Director, Transport Assessments Planning Services
Department of Planning, Industry and Environment
GPO Box 39
Sydney, NSW 2001

Application: SSI 7485

I write regarding the proposed modification to M4-M5 Link, Mod 2 The Crescent overpass and changes to pedestrian infrastructure in North Annandale, Rozelle and Rozelle Bay Foreshore area.

Figure 4-1 Overview of the proposed modification

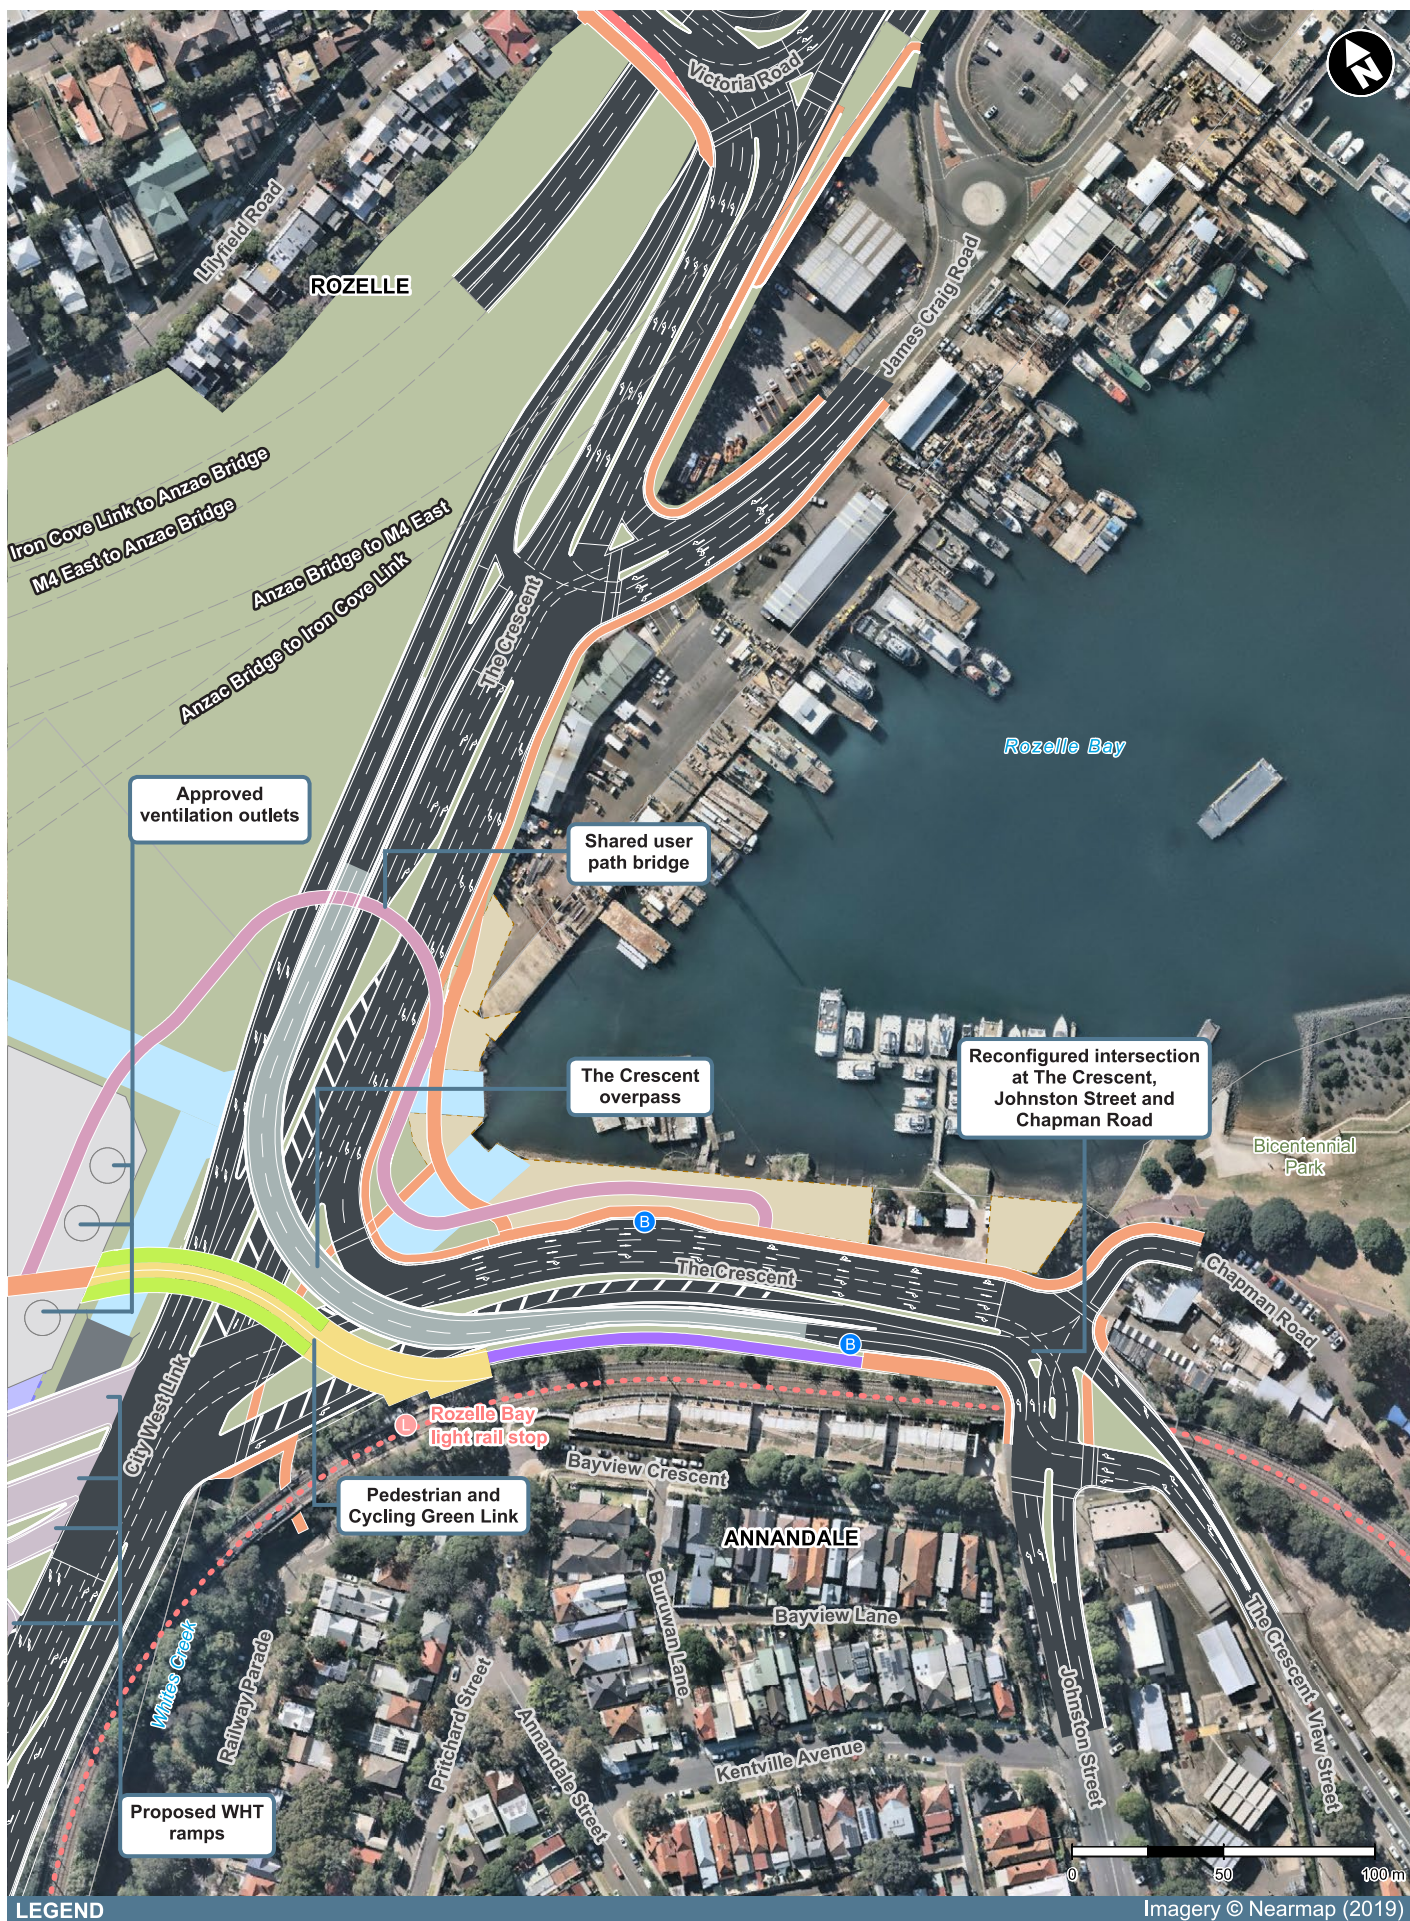
I request RMS work with the community to explore alternate design options to the proposed new car overpass design and the changed pedestrian and cyclist links. I am seeking the reinstatement of the safe, direct access from the approved EIS GreenLink to create a continuous green open space connection from the Rozelle Rail yards and Annandale to the foreshore. The GreenLink was more than just a walk way - it put people central to the design, maximising safety, and providing much needed accessible open space for the community now and into the future Bays Precinct design.

- The significantly reduced safety and increased risk for pedestrians and cyclists with removed access over The Crescent to Bicentennial Park and the increased traffic along Johnson Street.
- Being required to cross five sets of pedestrian lights at The Crescent as my option to reach the foreshore from Annandale or from Rozelle Bay light rail stop.
- Removal of direct active links to the foreshore, cutting the community off from the area and the proposed revitalisation of the entire Bays Precinct, including linking the Light Rail and Bus stops to a Ferry wharf and Metro station.
- Urban and landscape design that is being built before a finalised Masterplan for the area.
- Traffic changes that limit movements around the suburb and create further congestion in the local streets of Annandale, Forest Lodge, Glebe, Lilyfield and Rozelle with no planning to deal with these.

- Reinststate the GreenLink connecting communities and green open space from Rozelle to Bicentennial Park
- Relocate and design pedestrian and cyclist connections that are continuous, safe and direct.
- Design the modification infrastructure and active links in response to the character of the suburbs, the location of the foreshore and it's potential future development.
- Provide pedestrian and cyclist paths that maximise people safety and do not force them onto busier streets, unsafe concrete plazas and caged walkways.
- Integrate active and direct connections to all active transport – including the future Metro West and Foreshore Ferry Wharf.
